Proposed two storey extensions & alterations

Orchard Cottage Rectory Lane Angmering

Thank you for your internet representation made on 25th January 2012 which has been recorded as **an objection** with the comments as follows:

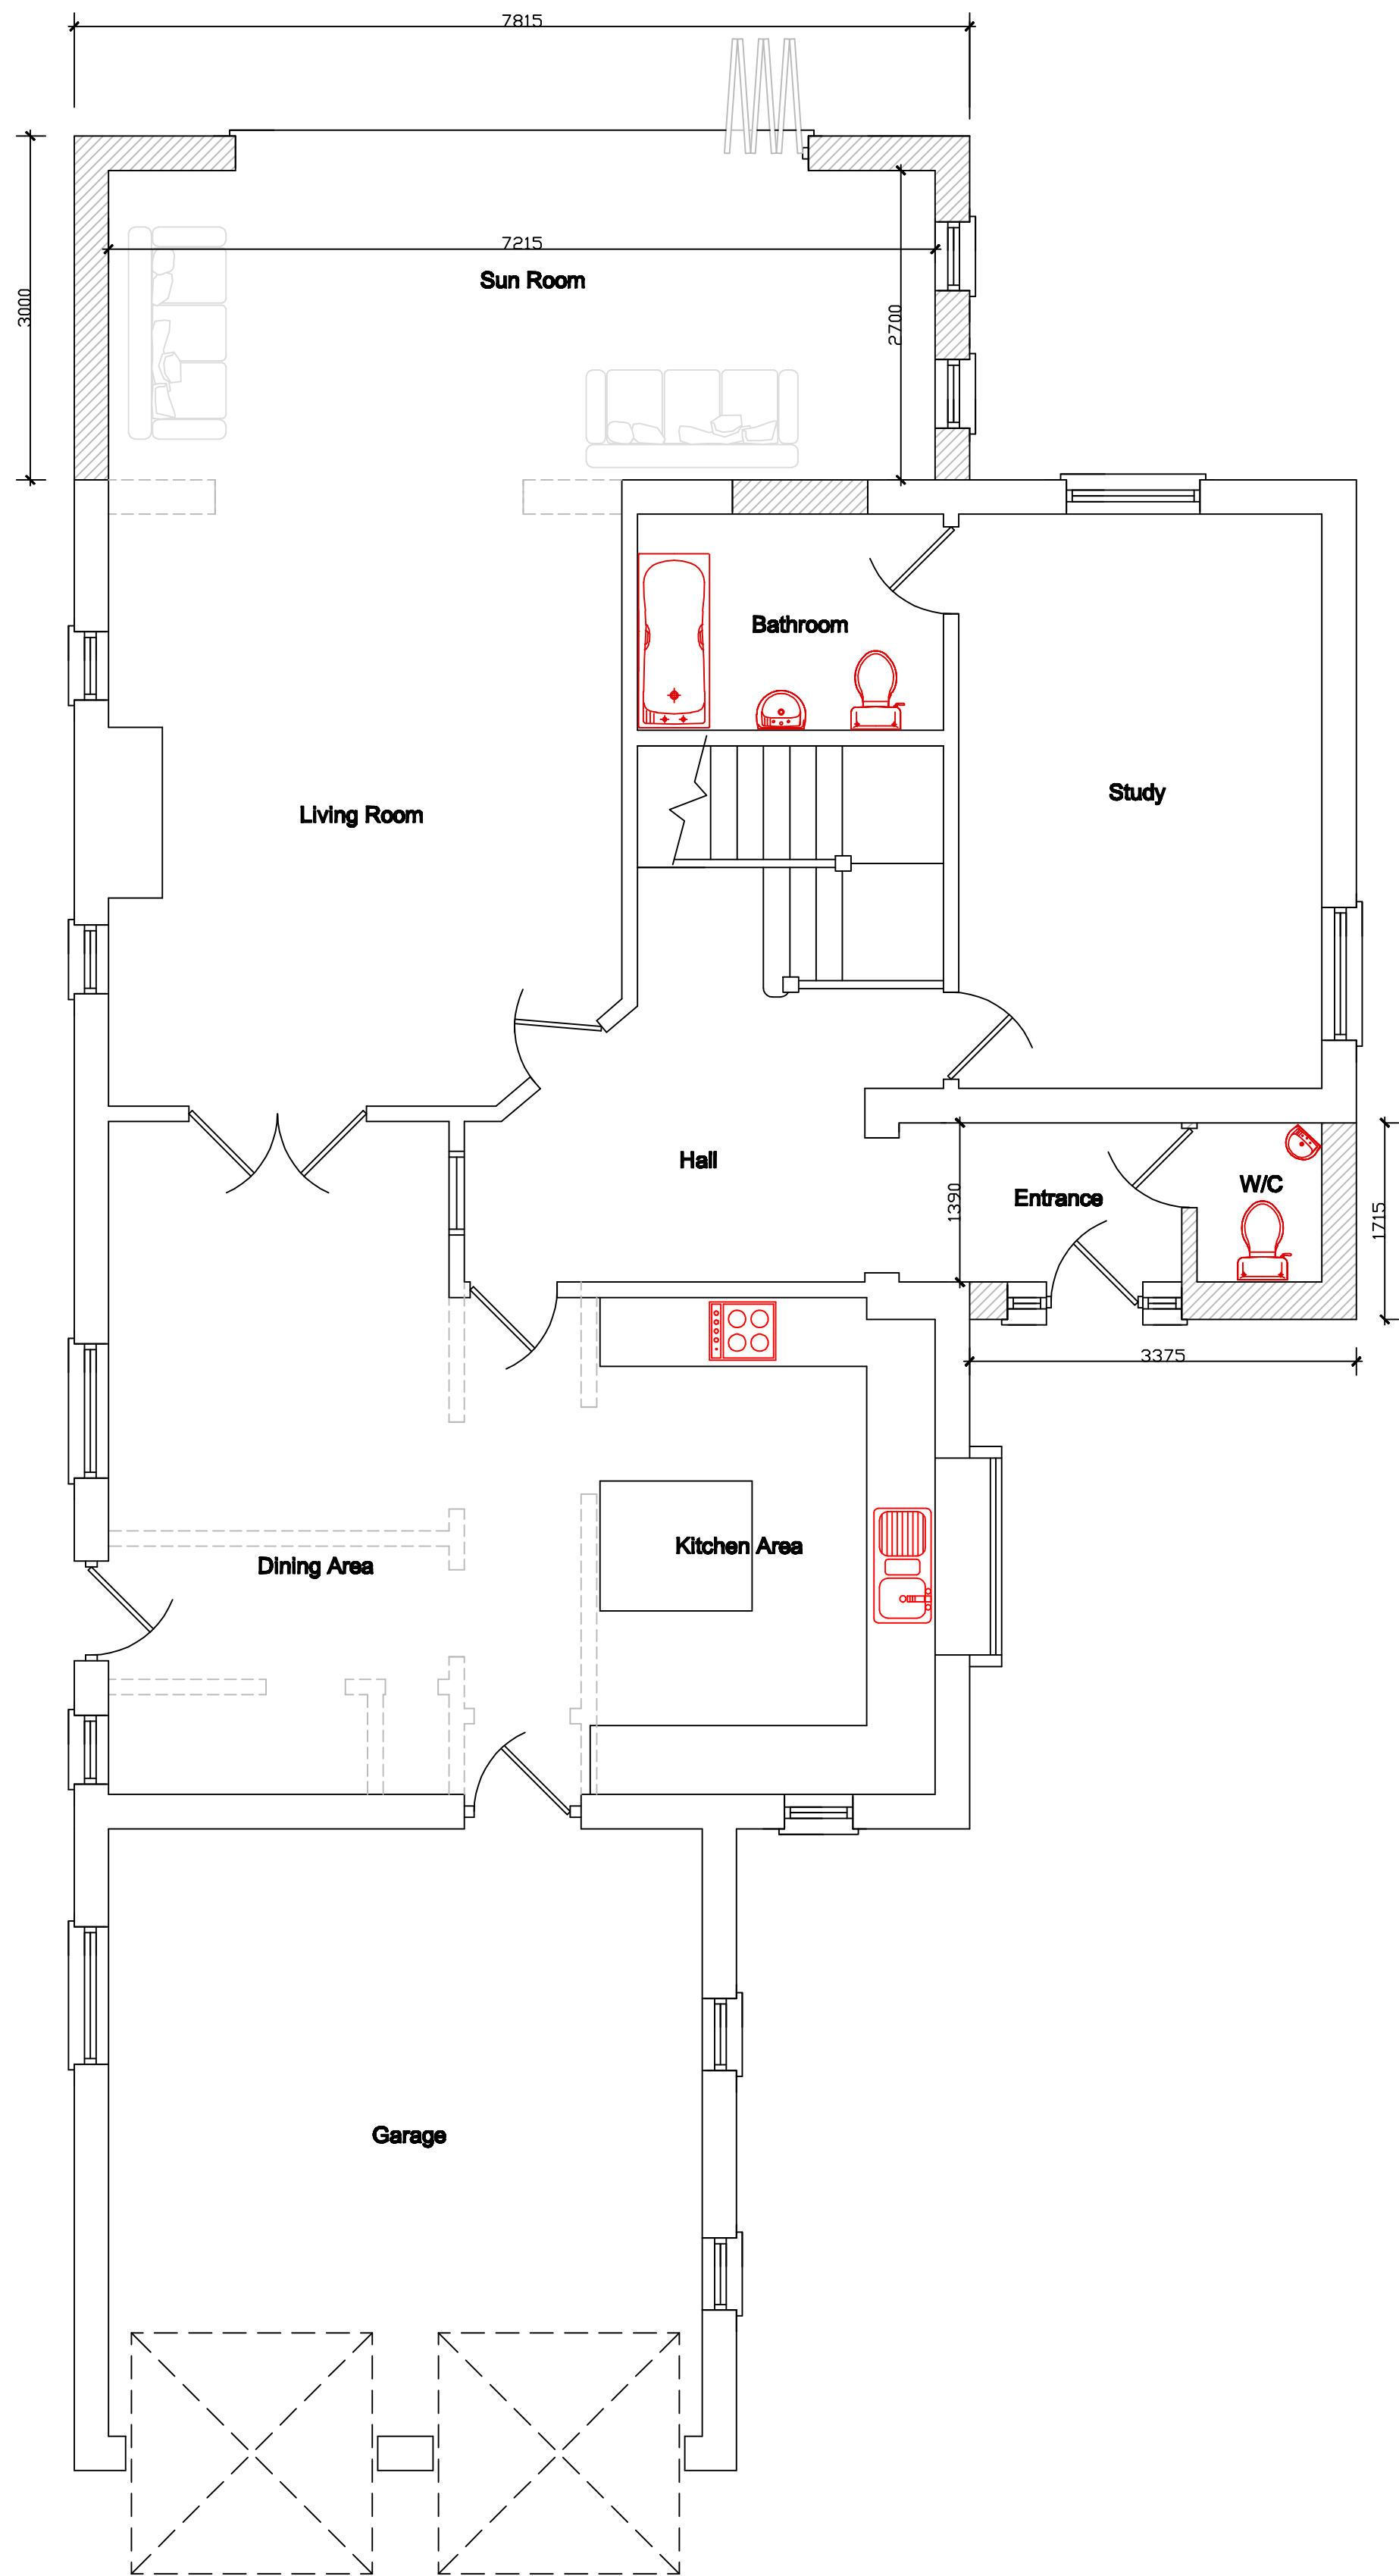
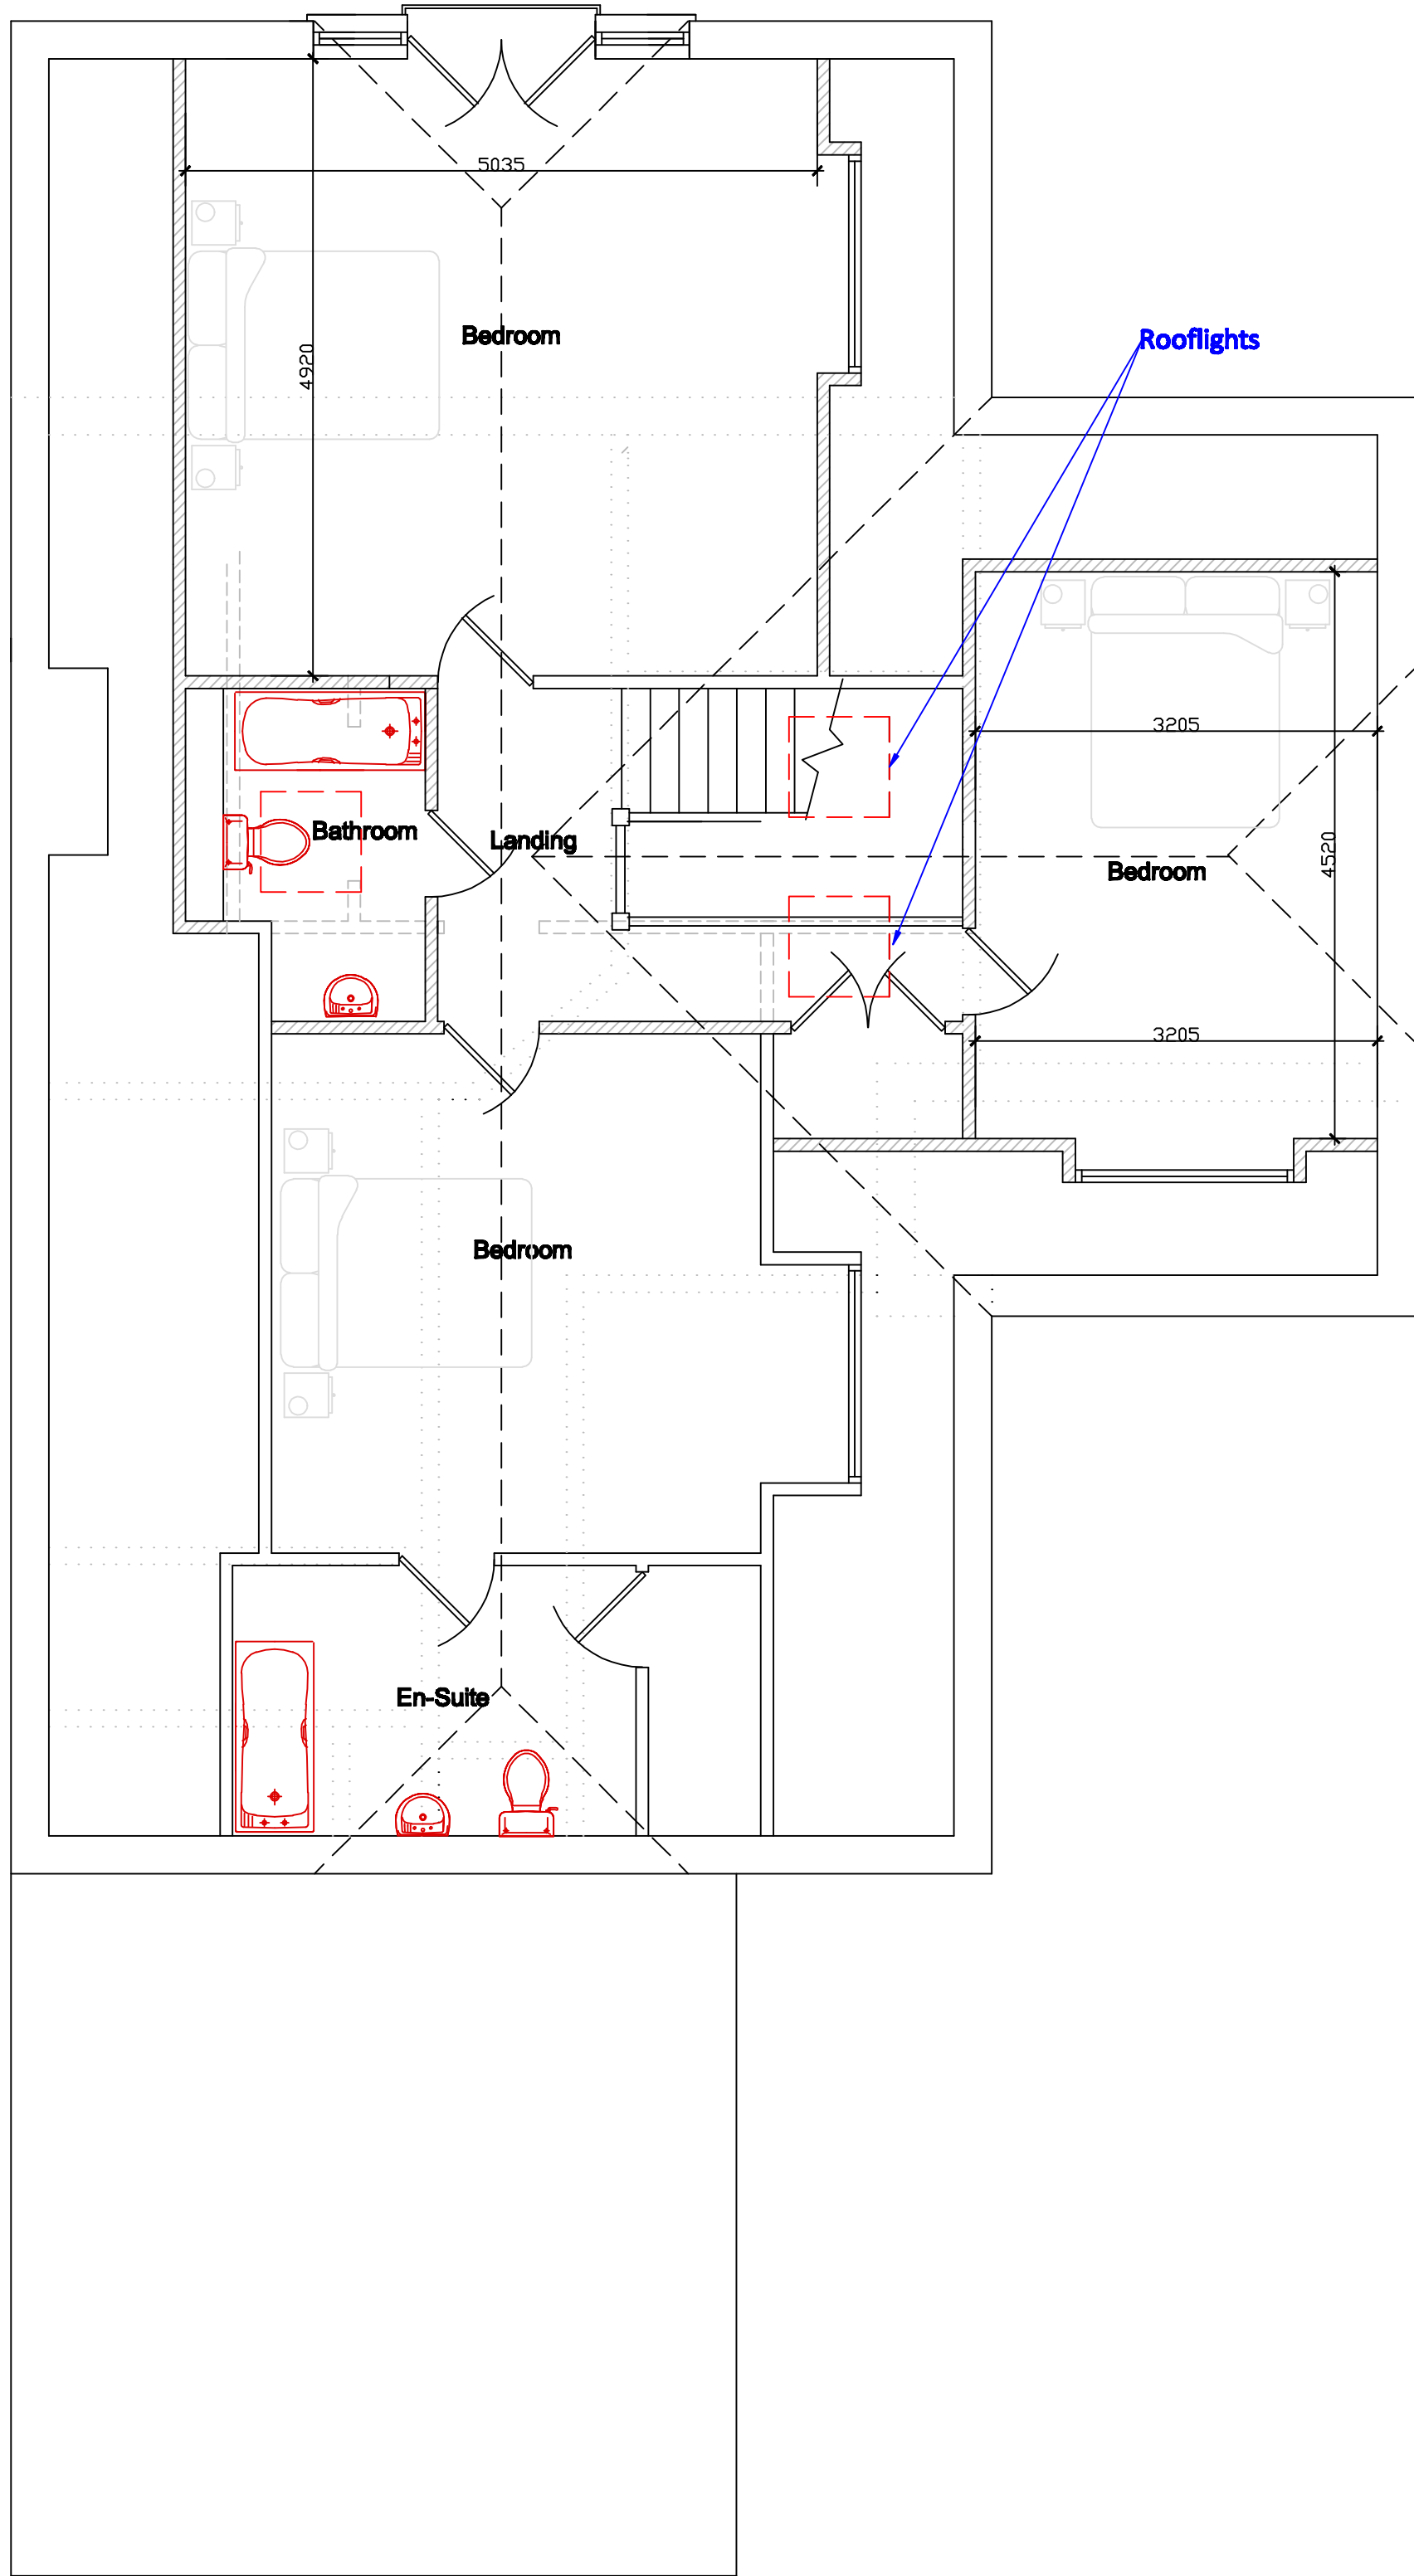
Amount: Though the proposed plans do not increase the footprint hugely, the proposed extensions would increase the ridge height significantly as well as the length of the roof. Both extensions, to the west and to the south, involve huge increases in the first floor space with corresponding increases in the size of the roof. These proposed increases are far too large for the plot on which the house stands. ☐

Layout: The existing cottage is already close to the property boundary on the western side in particular. If the extension were merely on the ground floor, it would not be too noticeable but the first floor part of the western extension would make it a large extension right on their boundary. The proposed southern extension, again would be too large because of the first floor part and the corresponding increase to the roof. ☐

Scale: I haven't calculated the % increase in cubic metres but this must be very large. The proposed new roof would be almost twice as long as the original ζ much too large in my view, especially when considering the proximity of neighbours on both sides and the size of the plot of land. ☐

Appearance: The existing cottage is quite discreet and tucked in, with the gabled roofs making it gentle on the eye. The proposed huge increase in the first floor area, even if made of high quality materials, would have a large visual impact and I don't mean in a positive sense!
